Date: 29 February 2024
Our Ref: 24/00153/CLPUD
Please ask for: Eleanor McCleary

Invalid Application

Proposal: Application for a certificate of lawfulness for proposed conversion of an existing garage to habitable accommodation
Location: Harrock View Three Post Green Mawdesley Ormskirk L40 3SU
Reference: 24/00153/CLPUD

Location Plan

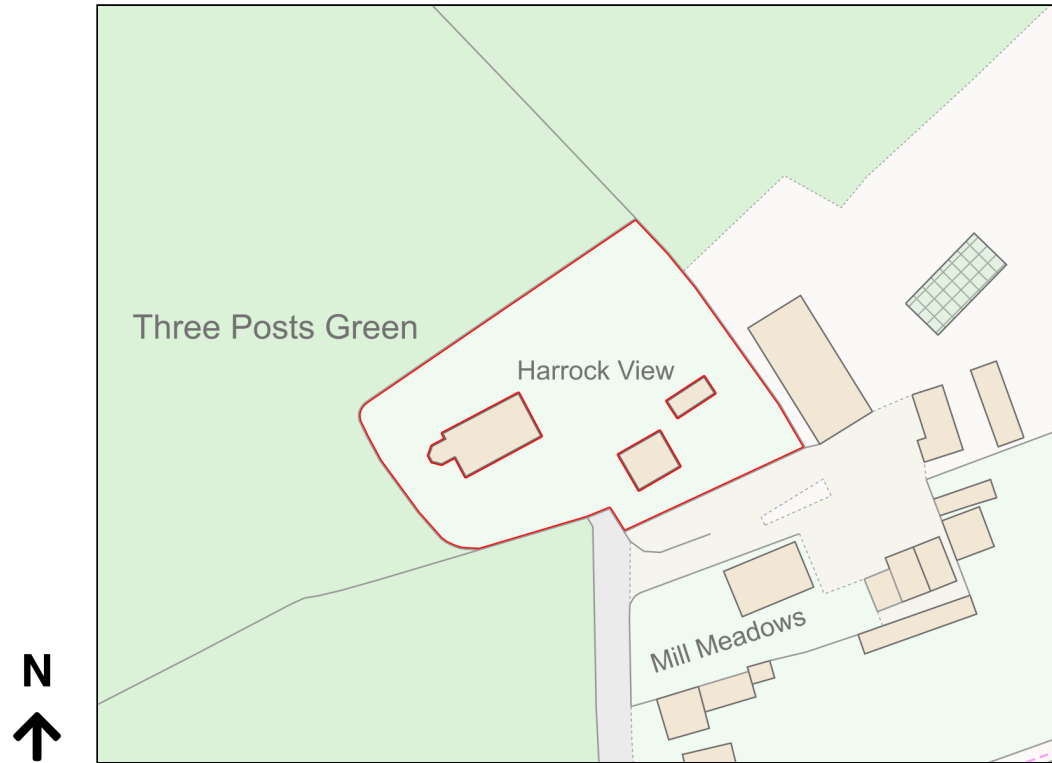
1. The location plan requires a red edge around the curtilage of the property. It is possible to purchase a location plan from [Buy a planning map - Buy a planning map - Planning Portal](#) and add a red edge.
2. You have paid a fee £289, however the fee for householder lawful development certificates is £129. You are therefore due a refund for the overpayment. Please contact 01257 515151 or email dcon@chorley.gov.uk and request a refund. Please quote the reference number 24/00153/CLPUD.
